CITY OF ALBUQUERQUE

February 22, 2019

**RE: 4600 Edith Blvd NE – SWMD Admin. Office and Vehicle Maintenance
Conceptual G&D Plan (Engineer's Stamp 4/29/2019)
Hydrology File: G15D202**

CONCEPTUAL GRADING & DRAINAGE PLAN

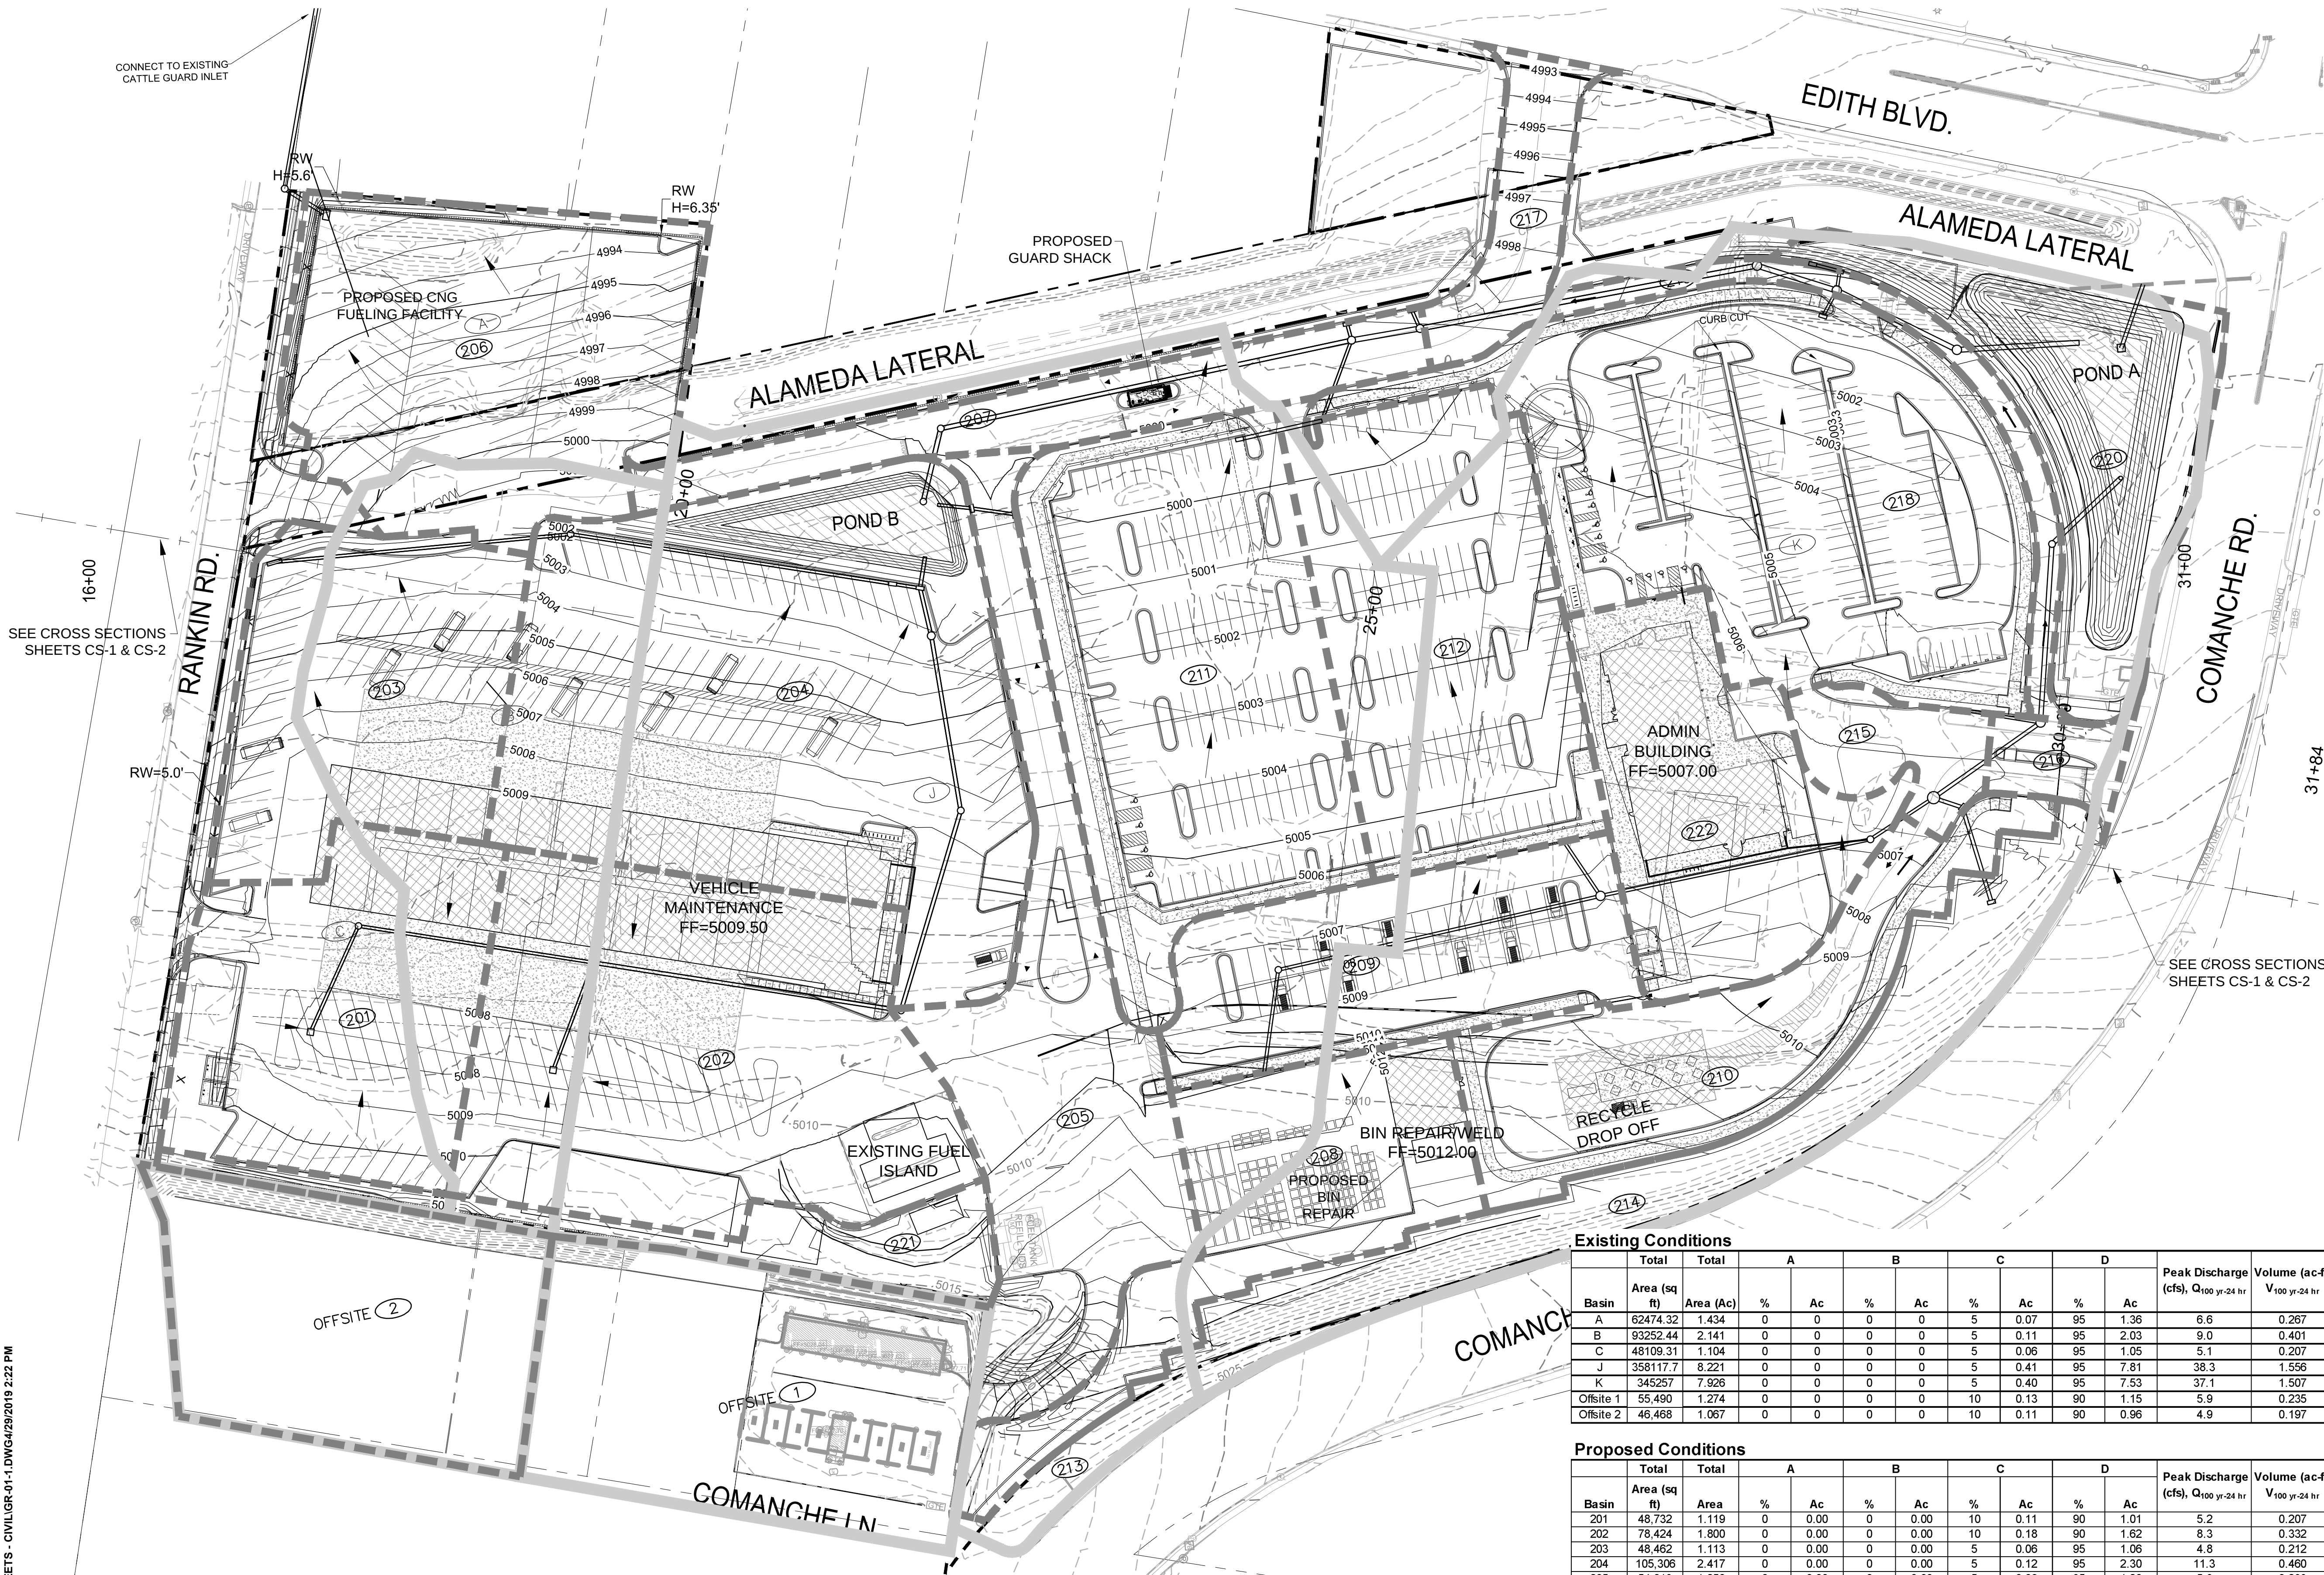
1. Please correct the Stormwater Quality Volume (SWQV) calculation at the end of the "Proposed Conditions" note on sheet GR-1. The required 80th percentile volume is 0.26" excess precipitation from the impervious area.
2. It appears that right of way dedication is needed along Rankin Rd. to contain the new C&G and Sidewalk. Please show the new Right of Way on the G&D Plan.
3. Add an inlet at the west end of the C&G in Rankin Rd. Identify the basin area draining to the new inlet and size the inlet(s) for total interception of the 100 year flows in Rankin Rd.
4. Please add a BMP, Pond C, for Basin 206 below the retaining wall.

5. Remove the label "Not for Construction" from the G&D Plan. Include an overall sheet like the Conceptual G&D Plan and provide a detailed design at a larger scale on multiple 24' x 36" sheets including many more spot elevations and details of the ponds.

7. Please add typical section of Rankin Road to the G&D Plan and include dimensions from the face of curb and sidewalk to the new right of way line. Also provide a typical section of the slope/retaining wall at the west end of the Rankin Rd frontage between the sidewalk and parking lot. The Retaining wall must not encroach into the public right of way.

15. Typical sections should be shown at numerous locations around the perimeter of the site. Each section should show the property line, both the existing and proposed grades, slopes and walls with dimensions, both horizontal and vertical, as necessary to demonstrate compliance with DPM 22.5.B
16. A Phasing Plan should identify which portions of the site work are to be completed with each building.
